Please ask for: Ms Iqraa Malik
Email: iqraa.malik@terraquest.co.uk
Telephone: 0121 234 1390
Our Ref: LU/300/21/HH
Your Ref:
Date: 28th September 2021

Application for Planning Permission for Works or Extension to a Dwelling

Development: Turning front garden into a driveway for disabled tenant and require a dropped kerb to access driveway.
Location: 142 Clun Road Wick Littlehampton BN17 7ET

Proposed domestic access
For 142 CLUN ROAD,
LITTLEHAMPTON, BN17 7ET
5.5m

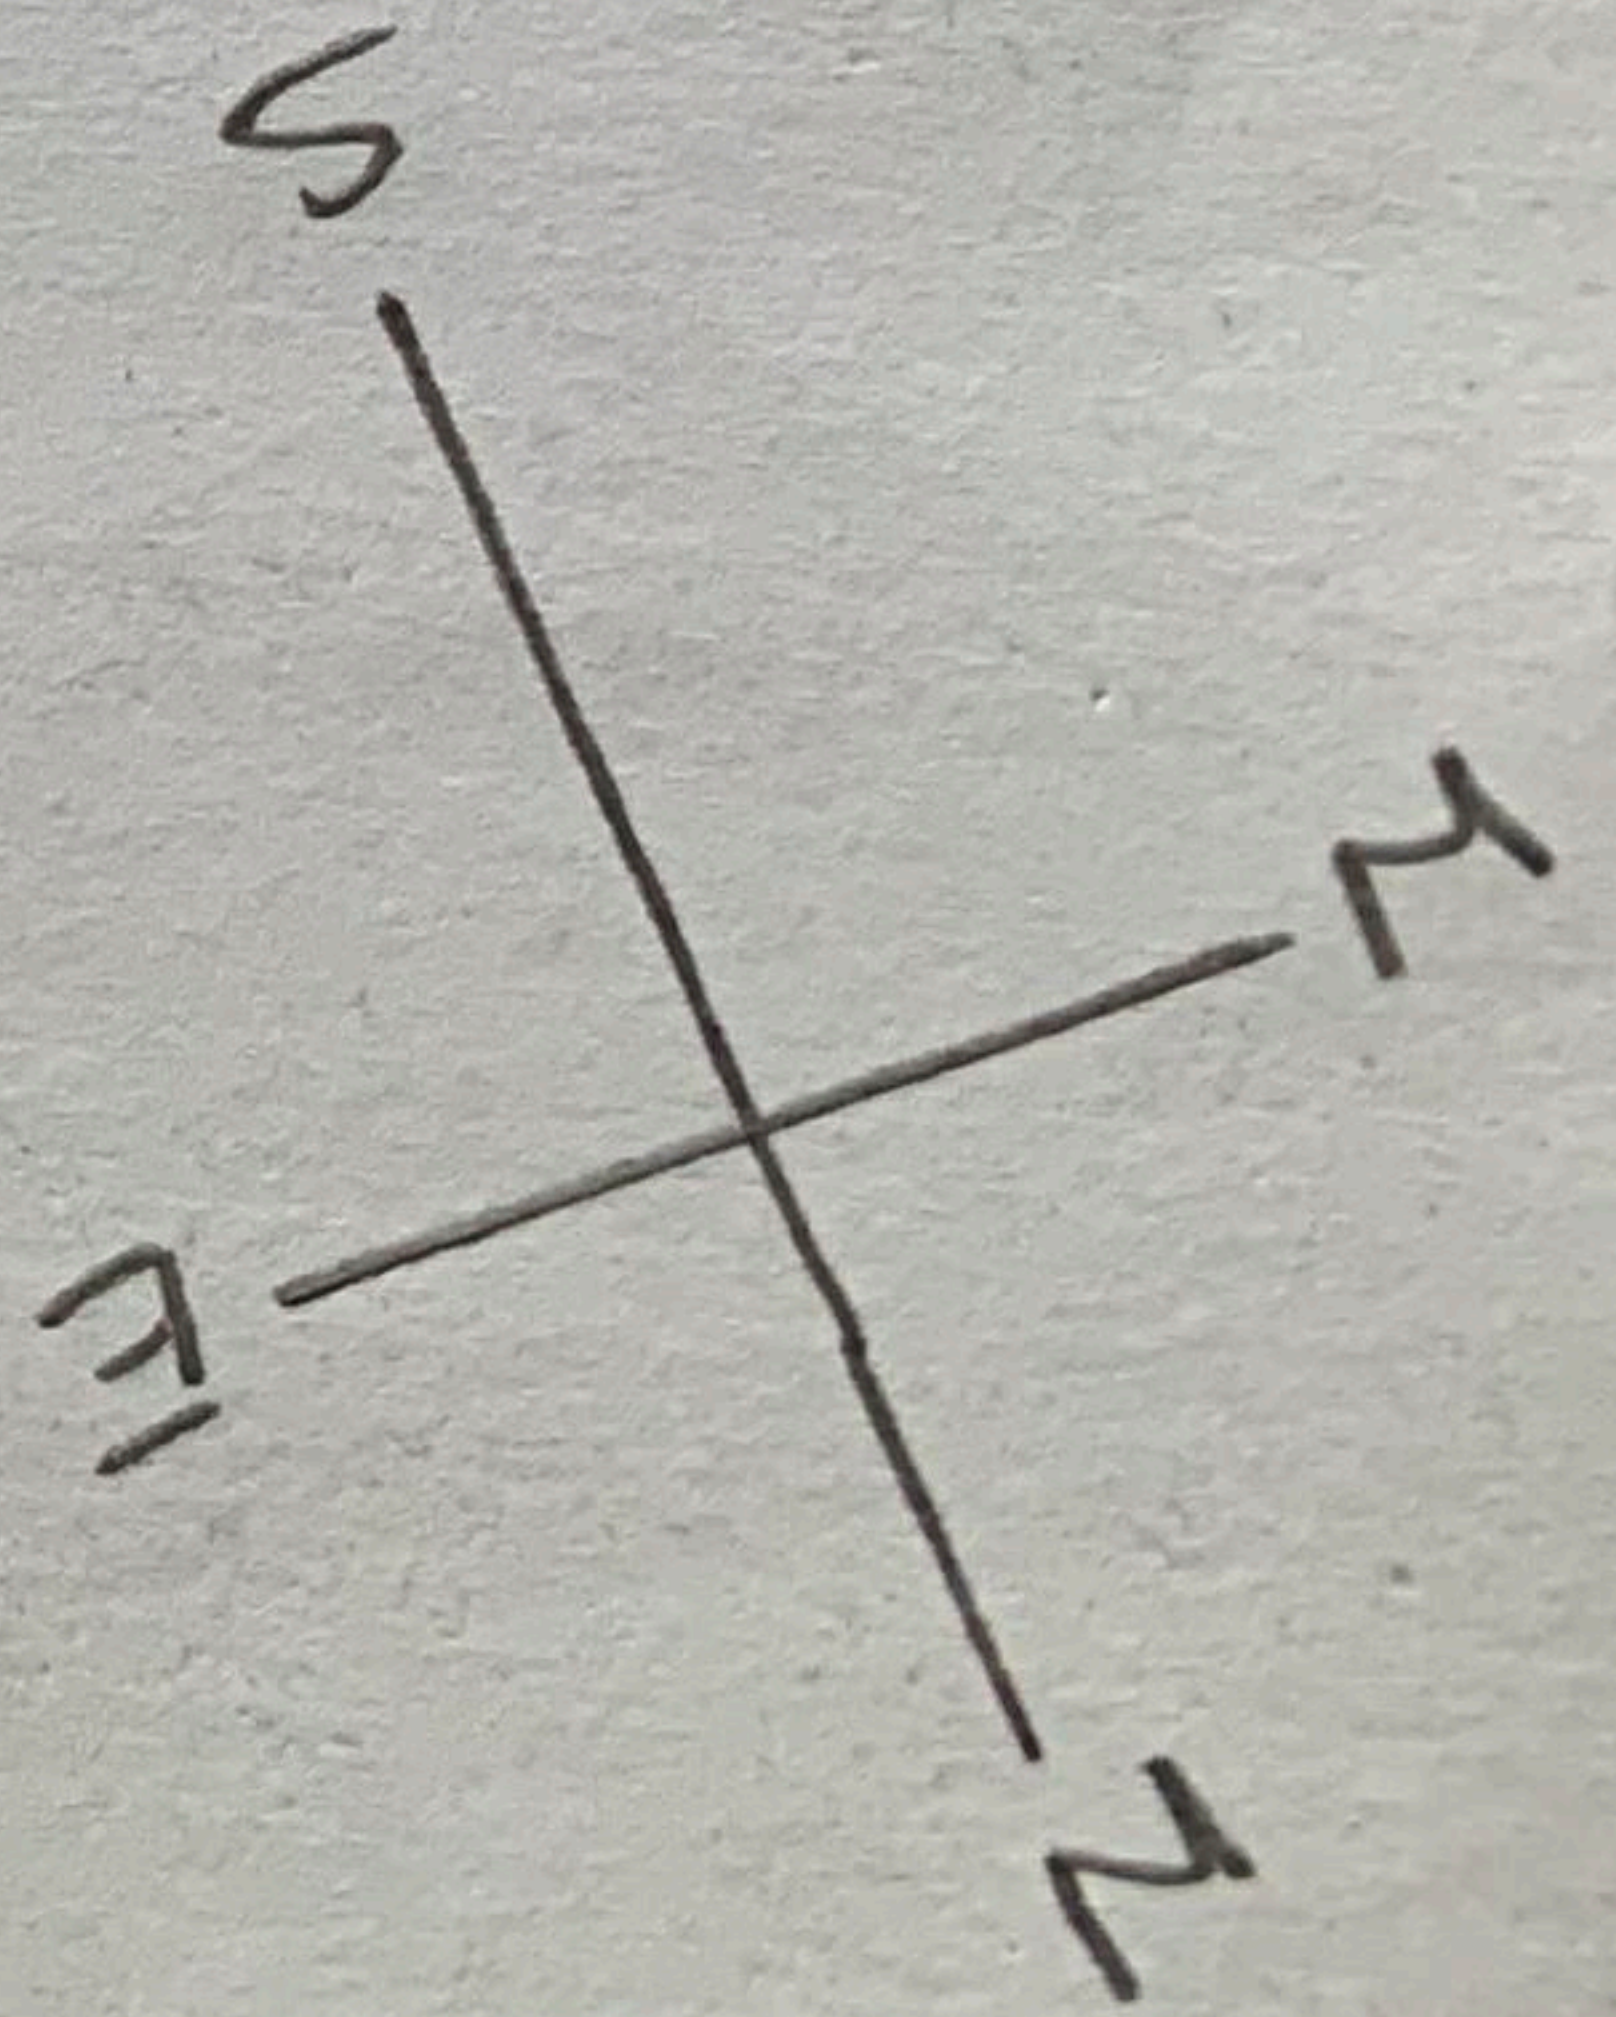
West Sussex County Council require that a visibility splay is provided. A splay is formed for a 30 mph speed limit road by measuring from a point 2.4m back from the kerb edge in the centre of the proposed access. A line should then be drawn from either side of this point for 43 m in each direction to the nearside edge of the carriage way. The splays must intersect land only within the control of the applicant, or within the publicly maintained highway.

Please submit existing and proposed plans of the driveway at a scale of 1:50 or 1:100. Further details can be found in the Validation Requirements List.

Block Plan

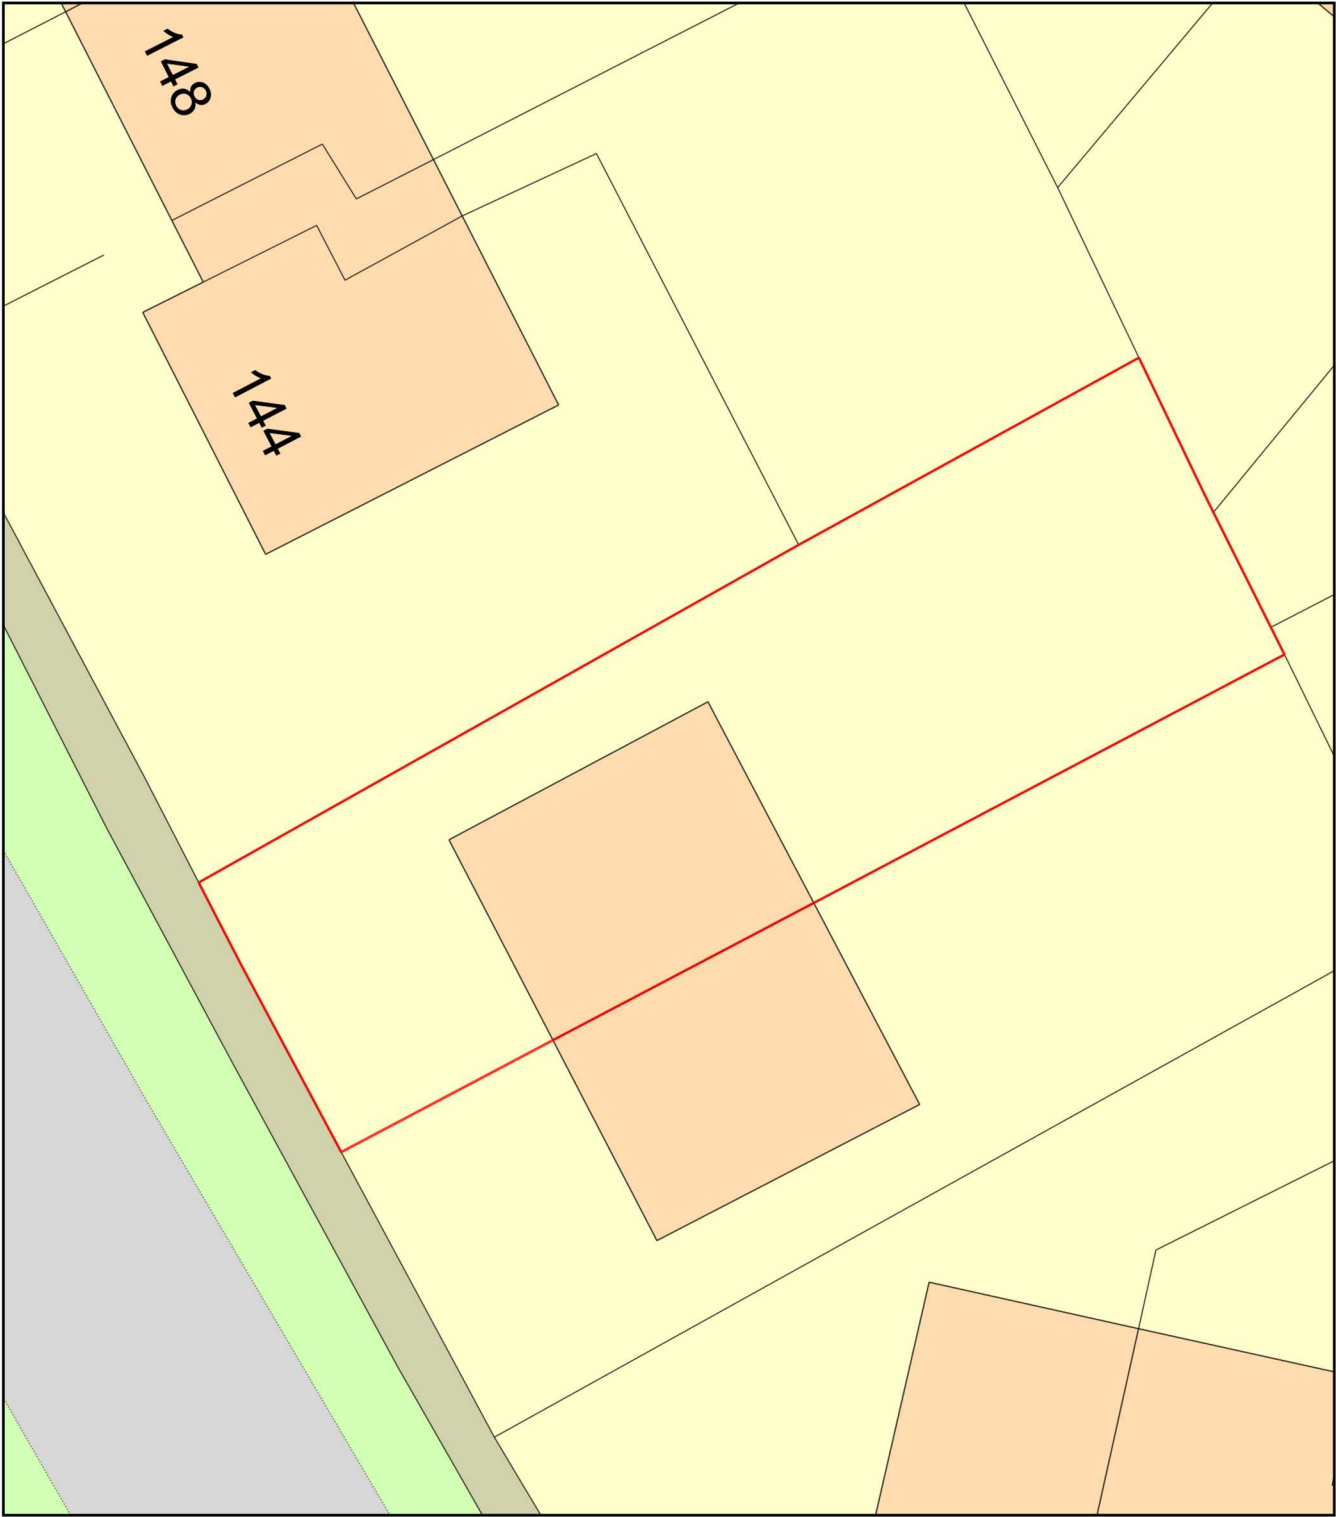
The red outline on the location and block plans needs to be around the site boundary and it needs to include the site property. Please amend.

Crossover Plan for 142 Clun Road Littlehampton BN17 7ET

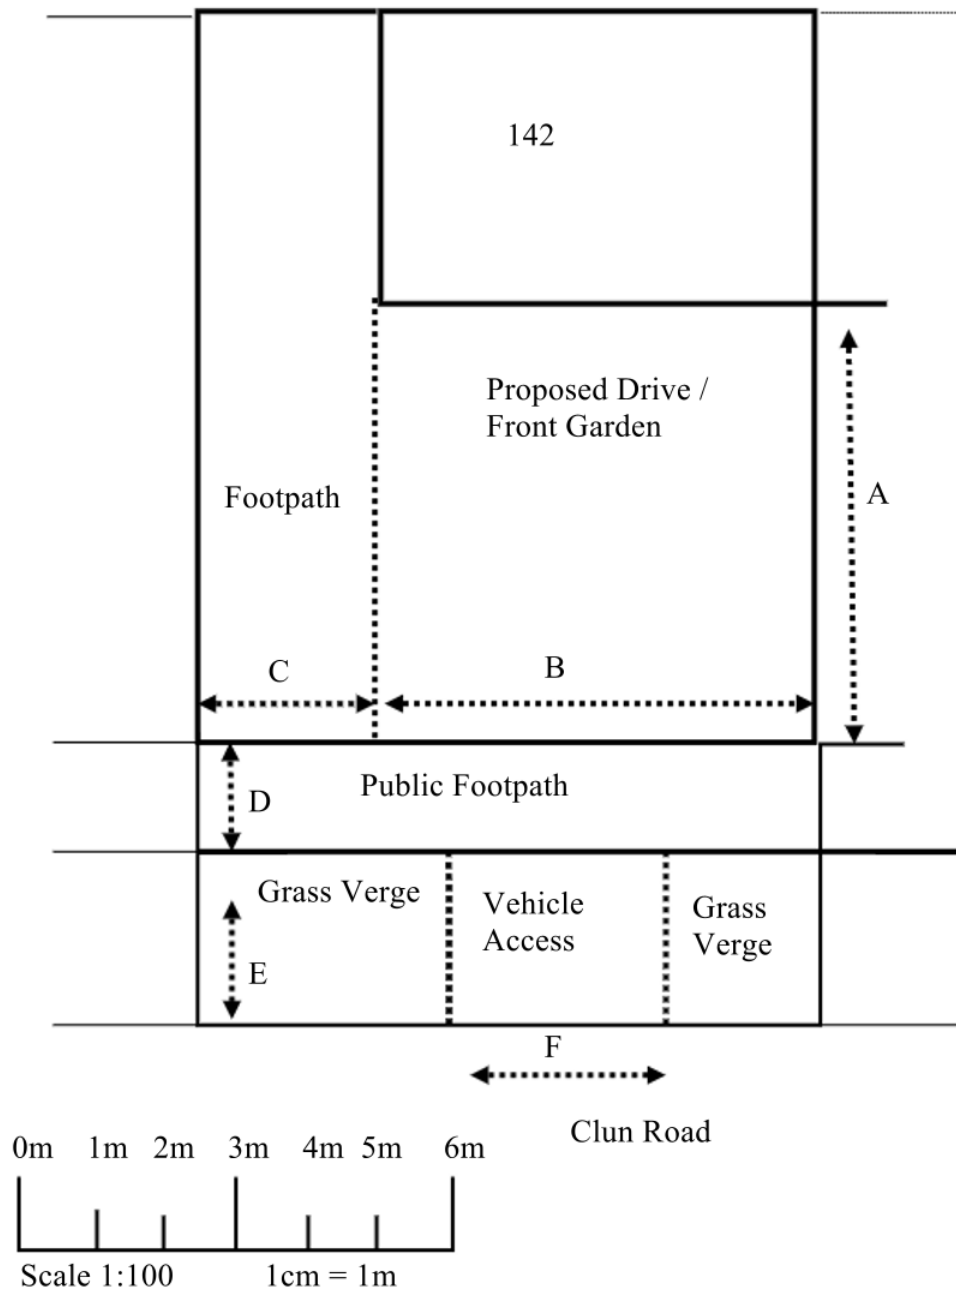
You are required to submit a scaled plan in PDF format of the crossover showing the width and depth of the proposed crossover.
